Consultation Response from KC,
Lead Local Flood Authority

2023/93388 Dene End Funeral Home, 50, North Road, Kirkburton, Huddersfield, HD8 0RW

Change of use from domestic to commercial, demolition of existing workshop and erection of three storey office building (within a Conservation Area)

Date Responded: 18th December 2023

DRAWING TITLE
LOWER GROUND FLOOR PLAN - PROPOSED

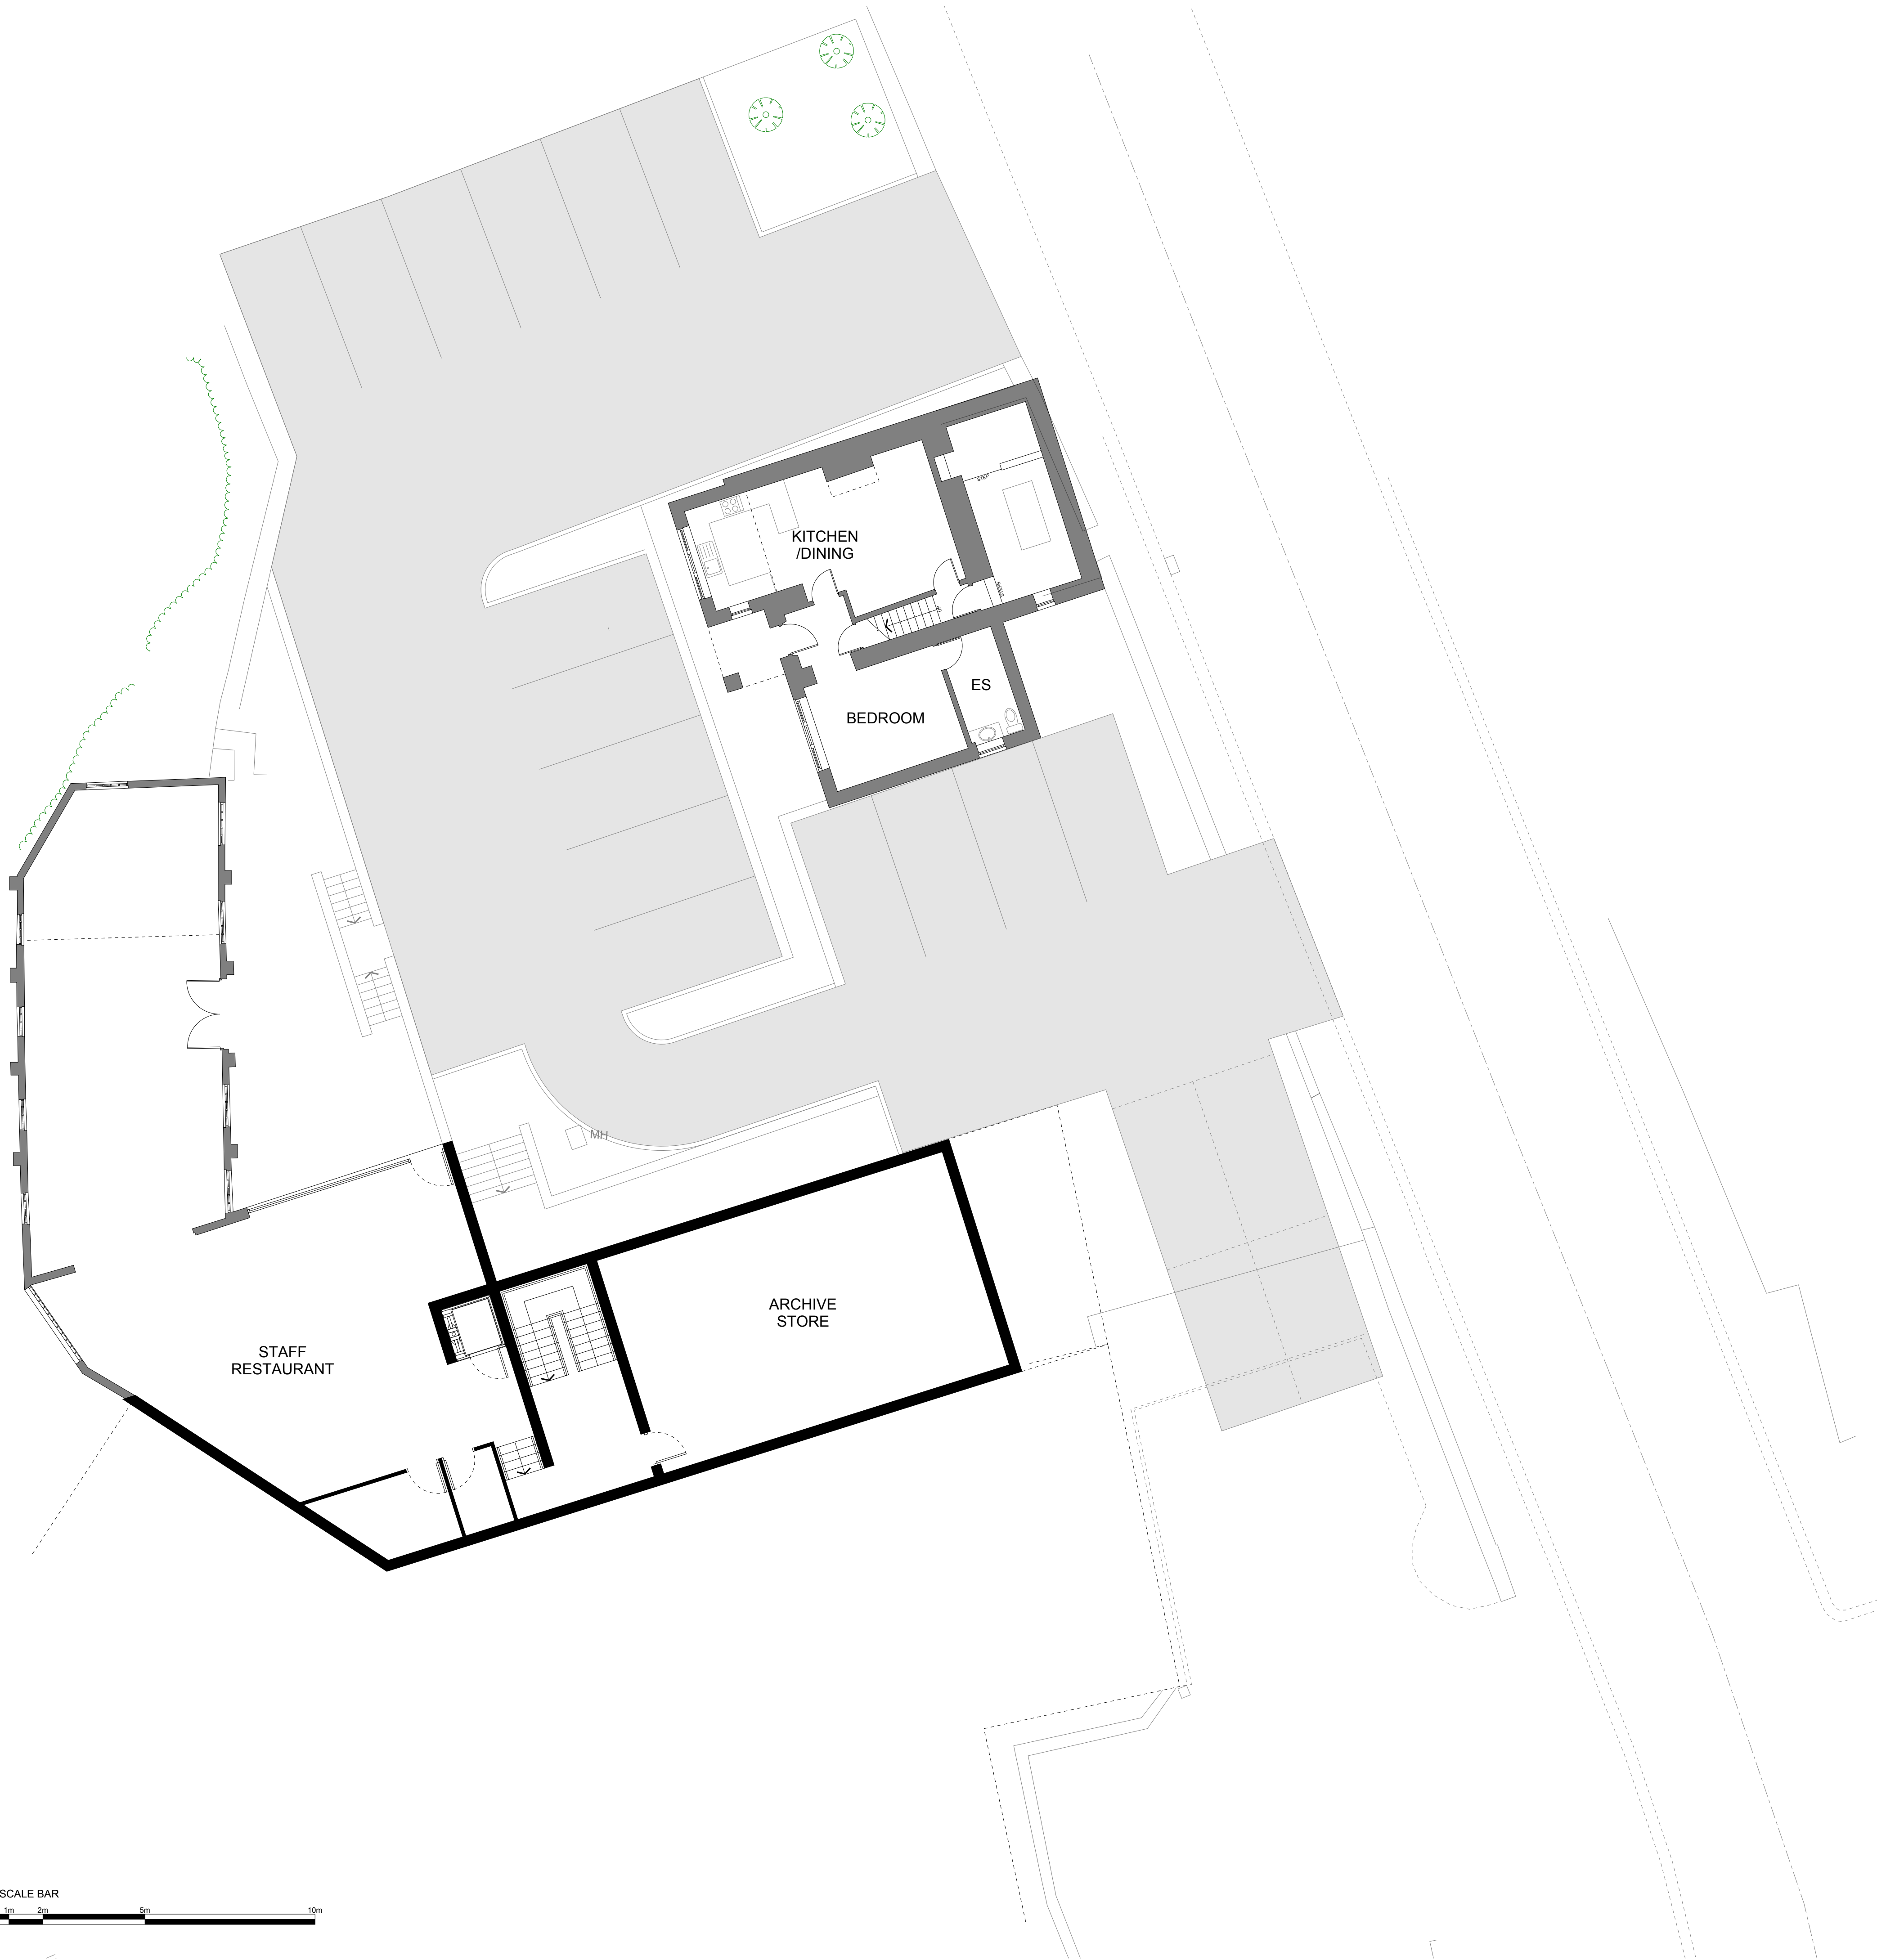
- Flooding has been recorded previously to Dene House (formerly Dene Works)
- Cellar Flooding has been recorded recently to no.50 of which there is a proposal to convert the lower ground floor (and upper floors) to a residential building, thus increase the consequences associated with this proven risk.
